**RE: St MATTHEWS CATHOLIC COLLEGE, MUDGEE (SSD 9872)
CORNER BROADHEAD ROAD AND BRUCE ROAD, SPRING FLAT (MUDGEE)
POST RESPONSE TO SUBMISSIONS – REQUEST FOR ADDITIONAL INFORMATION**

I write on behalf of Trustees of the Roman Catholic Church for the Diocese of Bathurst in relation to the current SSD DA for the new St Matthews Catholic College – Secondary Campus at the corner of Broadhead Road and Bruce Road, Spring Flat (Mudgee) and provide a response to requests for further information arising from our Response to Submissions package of early October 2020.

DRAWING TITLE
VEHICLE SIMULATION PLAN

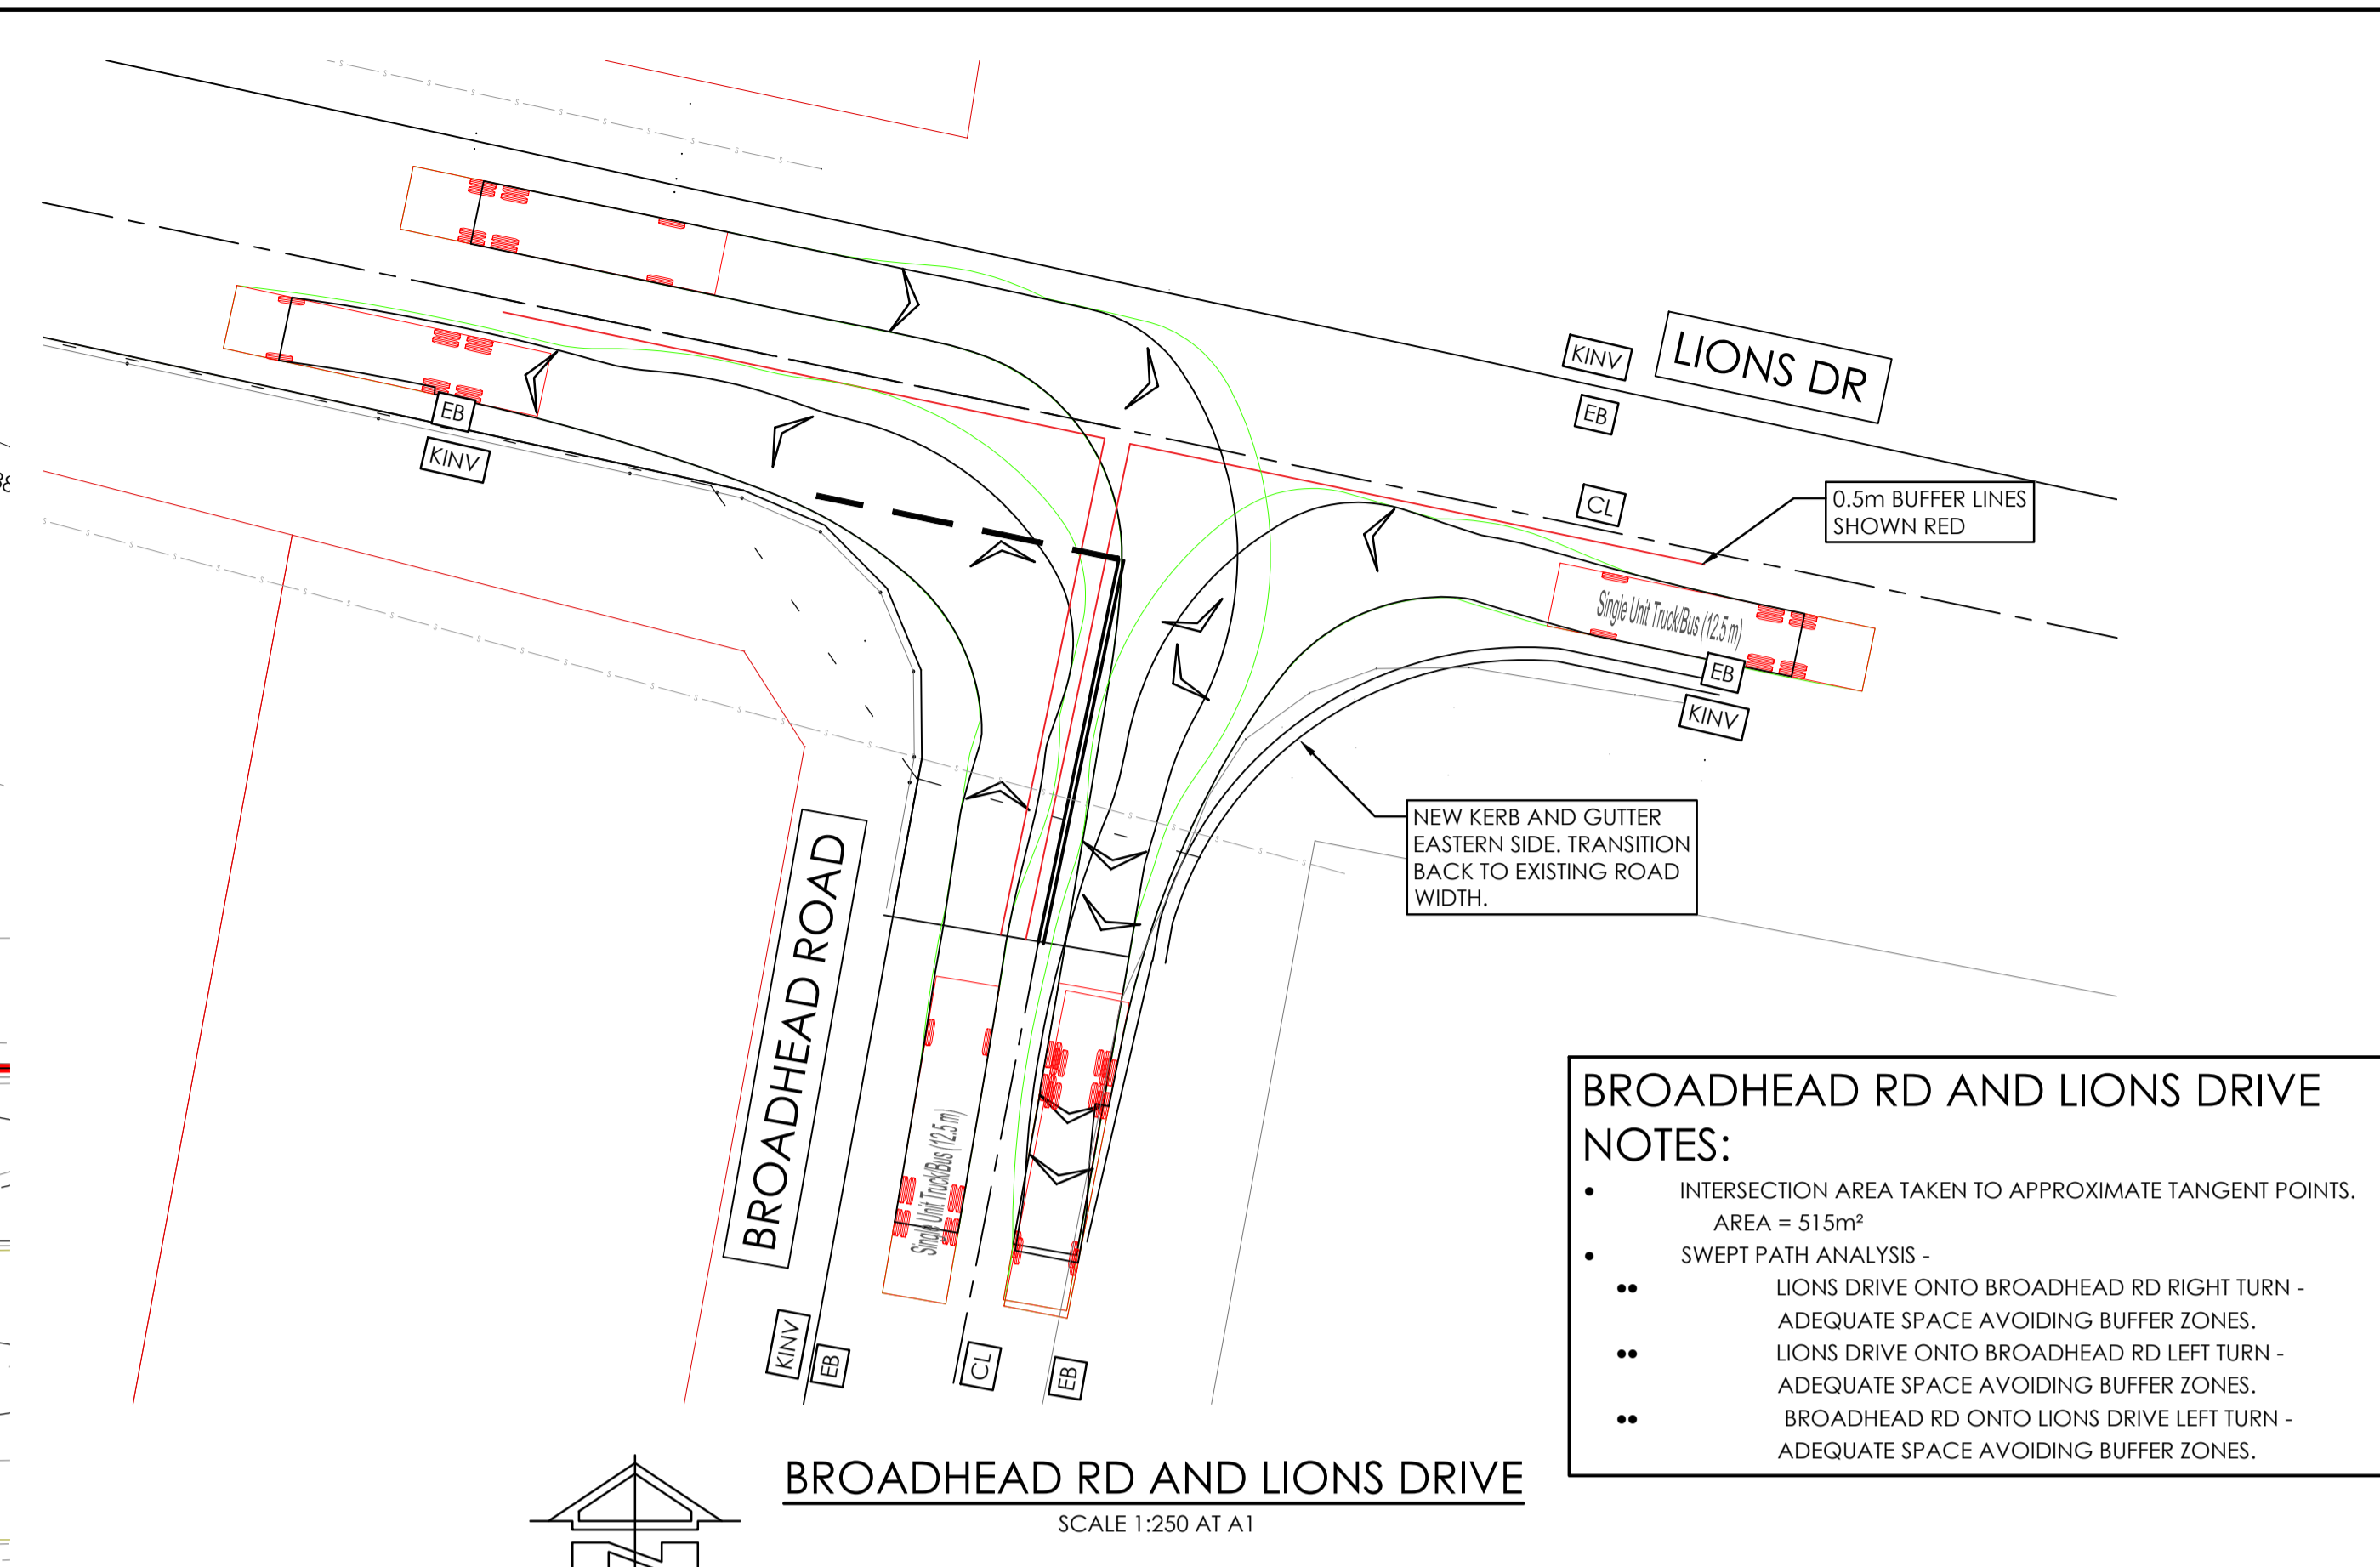
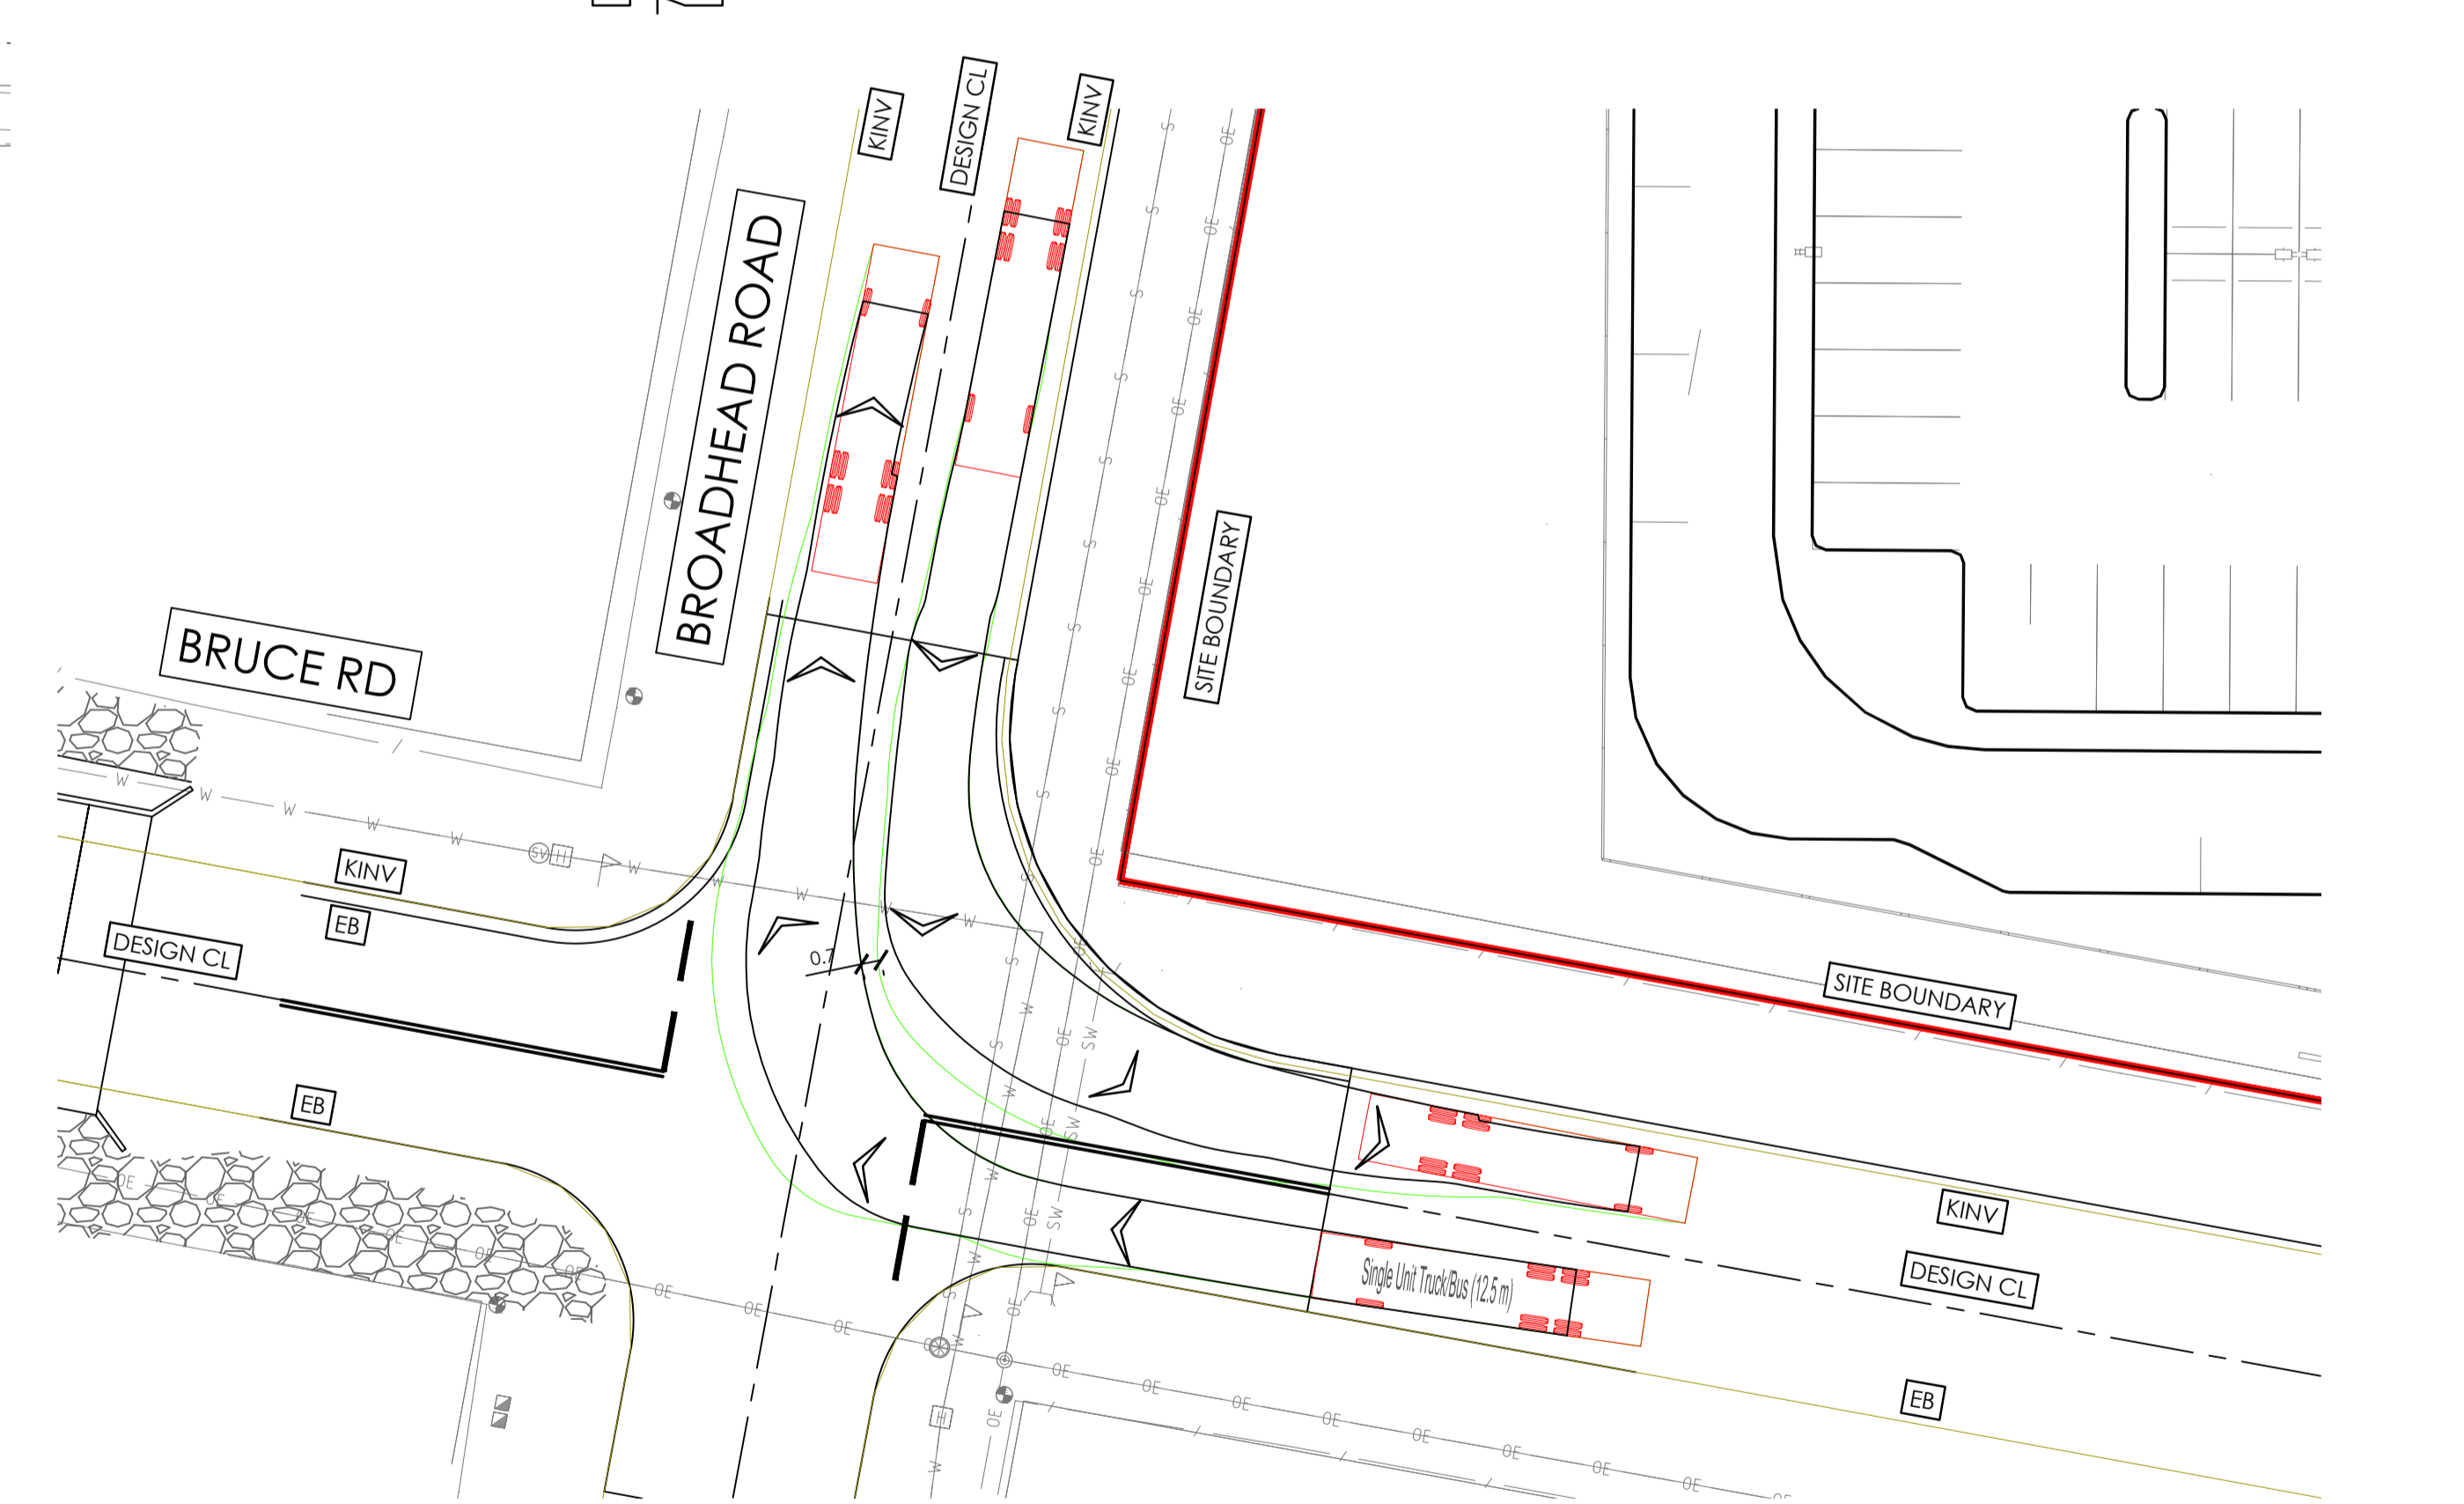
Agency Comments	Response
	<p>The bus lay by / bus bays (including their capacity and number) have been prepared in consultation with local bus operator (Ogdens) and Council. Neither raises concern.</p> <p>This suggested condition is not supported.</p>
Swept Path Plan	
<p>The swept path plan is to be revised identifying the largest vehicle required to access the site can do so safely, in particular via the Broadhead Road and Bruce Road intersection. The swept path plan is to be submitted to the consent authority and TfNSW. It is noted the current swept path plan provided by the proponent does not include the centrelines for the intersection of the Broadhead and Bruce Road intersection, the 12.5m vehicle identified in the swept path plan can only technically manoeuvre within the correct lane.</p>	<p>The largest vehicle likely to visit the site is a 12.5m bus (as used by Ogden's – the school's bus service provider). The swept path analysis by Triaxial (see attached) is based on this length. Note the vehicle size of a garbage truck is a maximum of 8.8m length (as used by the proposed contractor JR Richards). Accordingly, there should be no corresponding difficulty in this sized vehicle visiting the site.</p> <p>Based on a 12.5m long bus visiting the site via Broadhead Road and returning in the same direction, this vehicle will be able to turn from Lions Drive into Broadhead Road and then from Broadhead Road into Bruce Road in a lane correct manner in each instance. Sufficient road width also exists to enable buses in opposing directions to use the same intersections concurrently.</p> <p>Once at the school and exiting the bus bay, the bus will be able, with continuous forward motion, to turn within the turning bay and re-enter Bruce Road in a lane correct manner. As noted, the largest likely service vehicle (at 8.5m) will easily be accommodated by the bus turning bay to continue into the school for servicing purposes.</p> <p>Accordingly, this matter can now be resolved as part of the assessment of the DA and be excluded from any draft conditions.</p>
